CITY OF ALBUQUERQUE

August 30, 2019

RE: 1817 Bluffside NW
Grading and Drainage Plan
Engineer's Stamp Date: 08/17/19
Hydrology File: H11D015B

ENGINEER'S SEAL  10/21/19 DAVID SOULE P.E. #14522	1817 BLUFFSIDE	DRAWN BY: WCMJ
	GRADING AND DRAINAGE PLAN	DATE: 8-16-19
 Rio Grande Engineering 1606 CENTRAL AVENUE SE SUITE 201 ALBUQUERQUE, NM 87106 (505) 872-0998		2109067-LAYOUT-8-15-19
		SHEET #
		JOB # 2109067

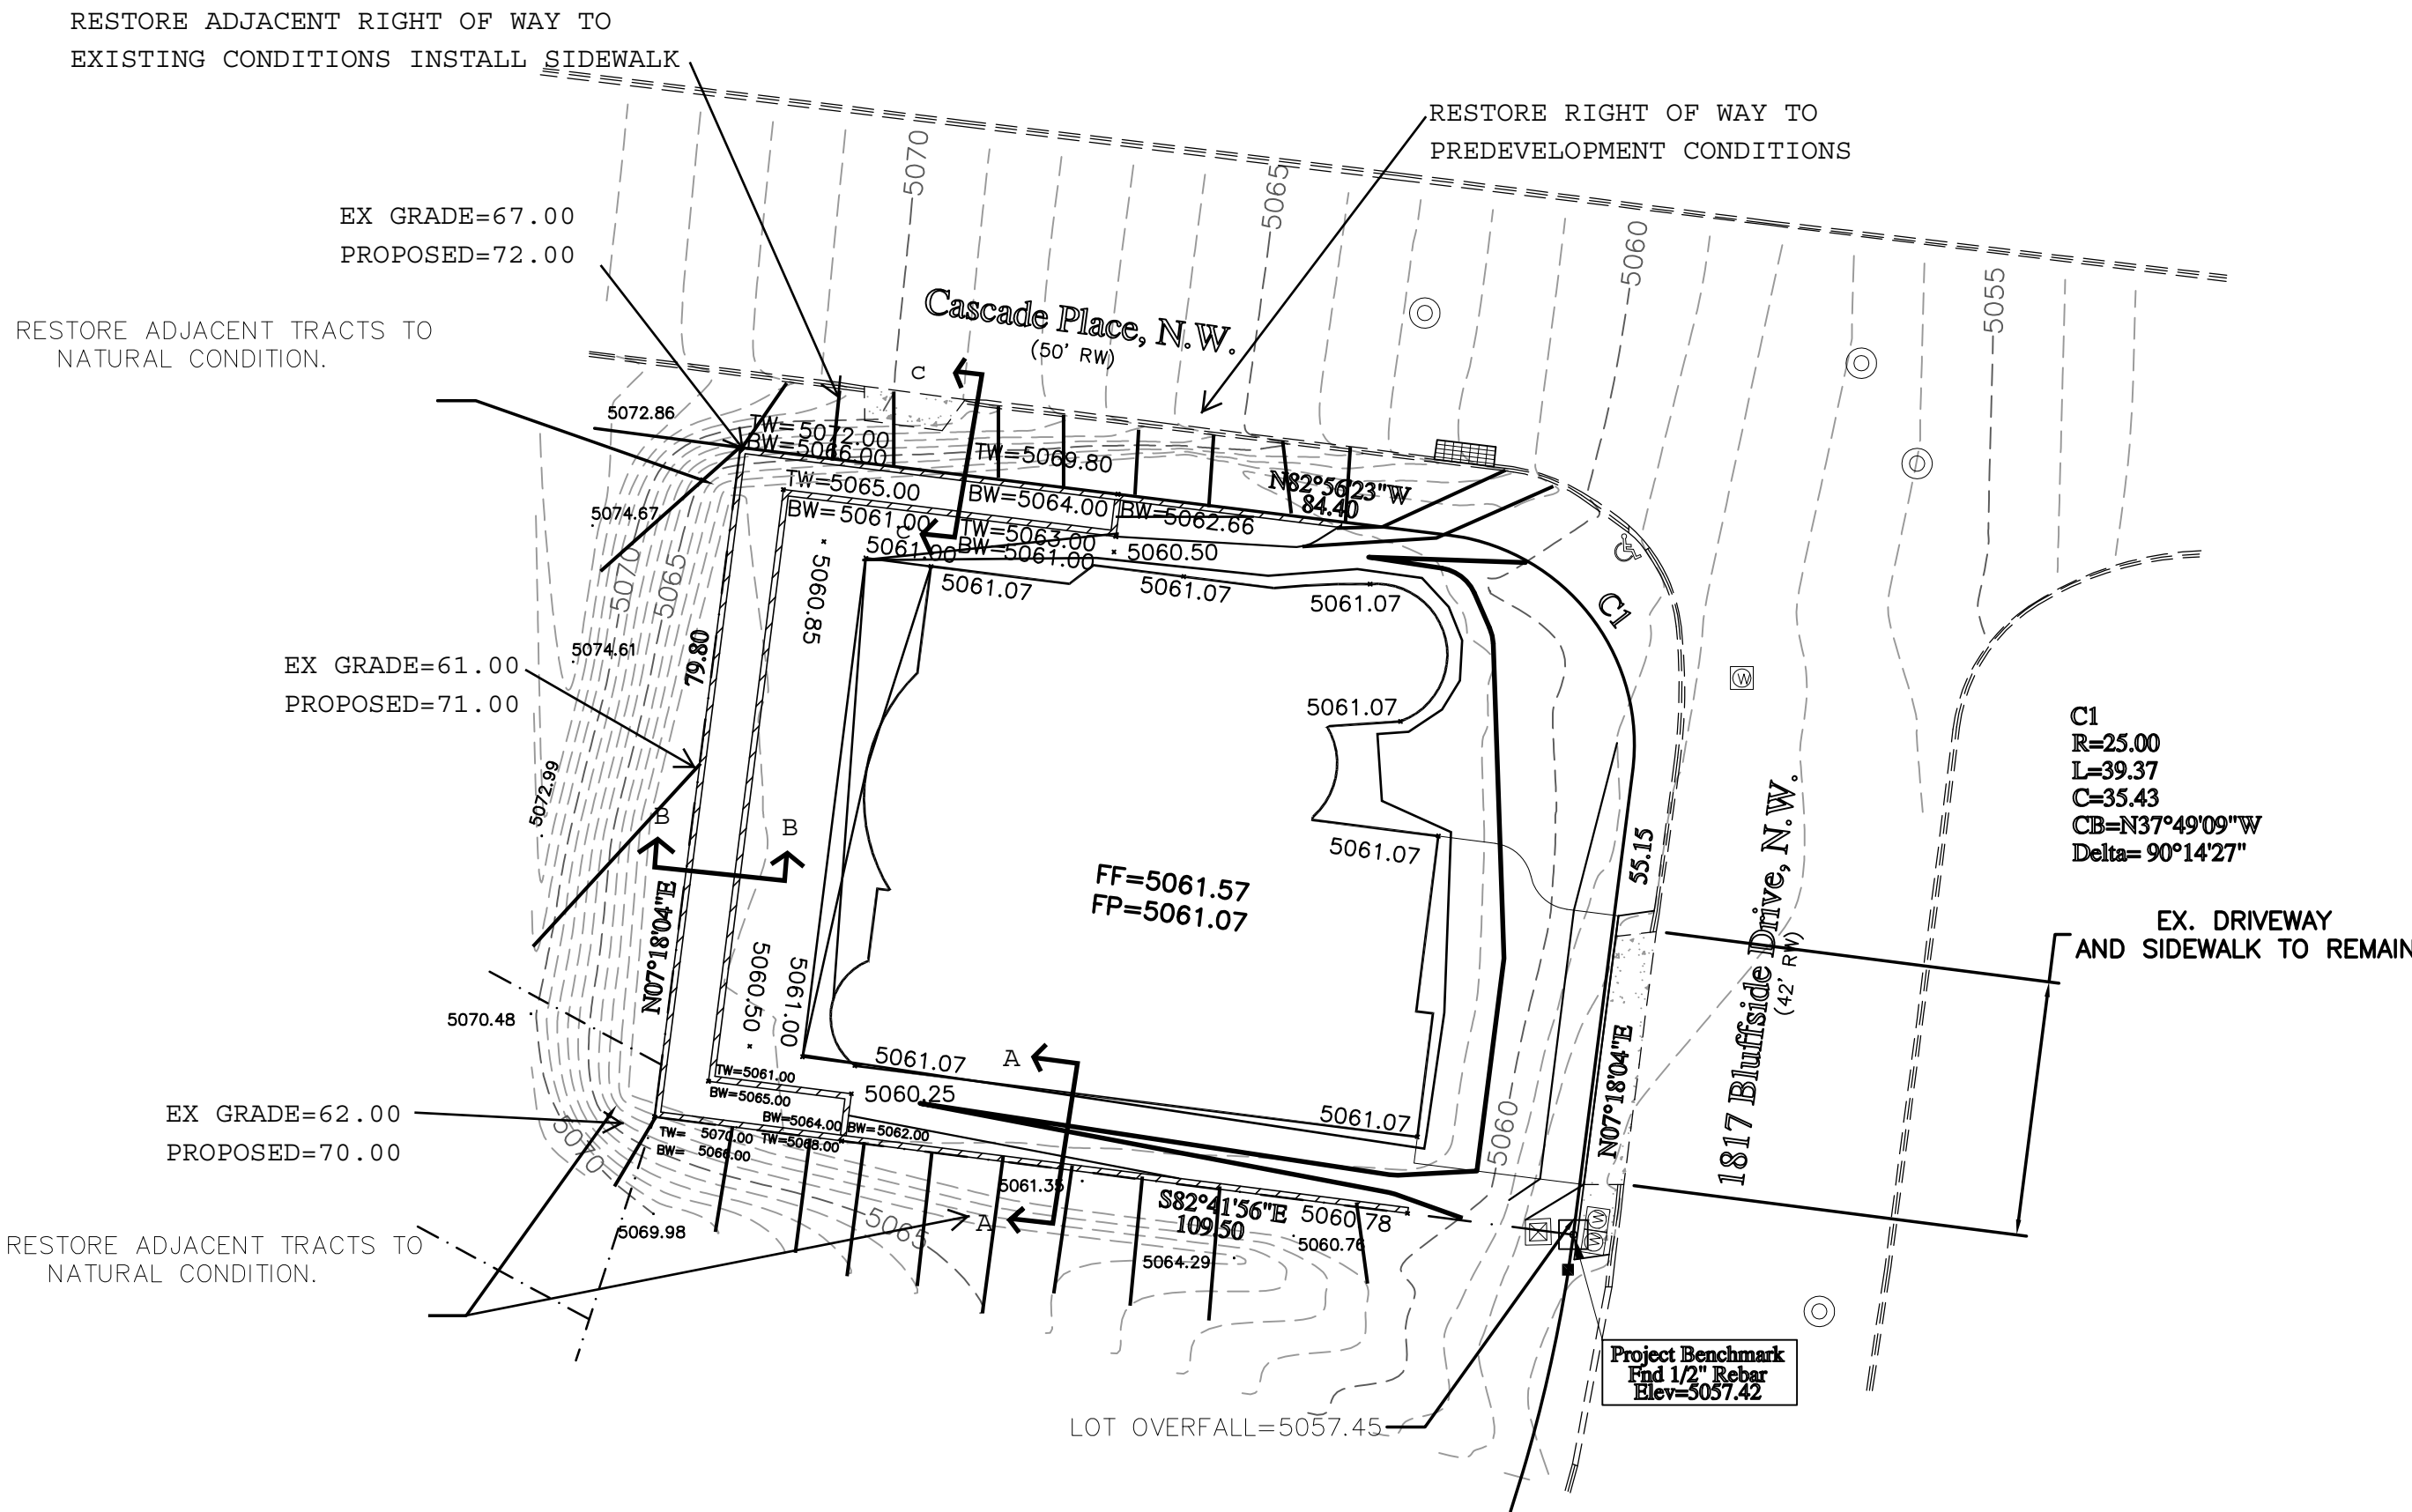
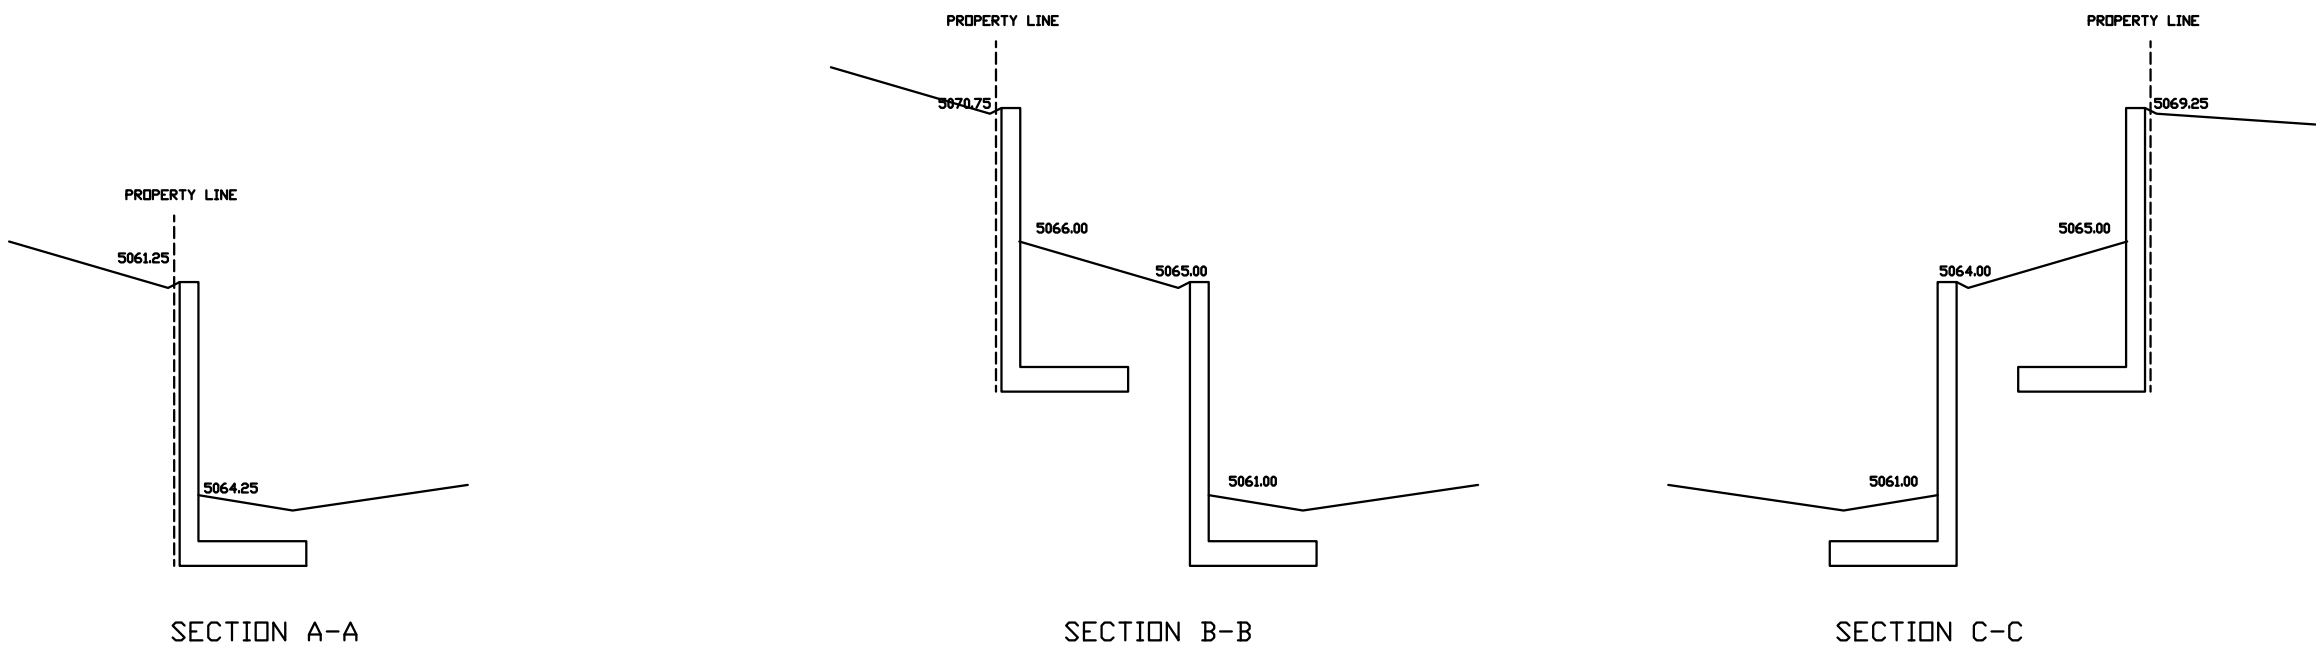
1. The topographic survey does not show the existing conditions along Casade Place correctly. As you can see in the July 24, 2019 photos show the vertical cuts that were not caused by drainage. This needs to reflect what the Owner's contractor graded within the public Right-of-Way along Casade Place NW.

2. Provide the existing and proposed grades on both sides of the proposed retaining wall.
3. Provide sections through all external boundaries showing proposed retaining walls, garden walls, property/ROW lines, existing and proposed grades. In accordance with DPM Ch.22, section 5 part B, grading and wall construction near the property line may not endanger adjacent property or constrain its use.
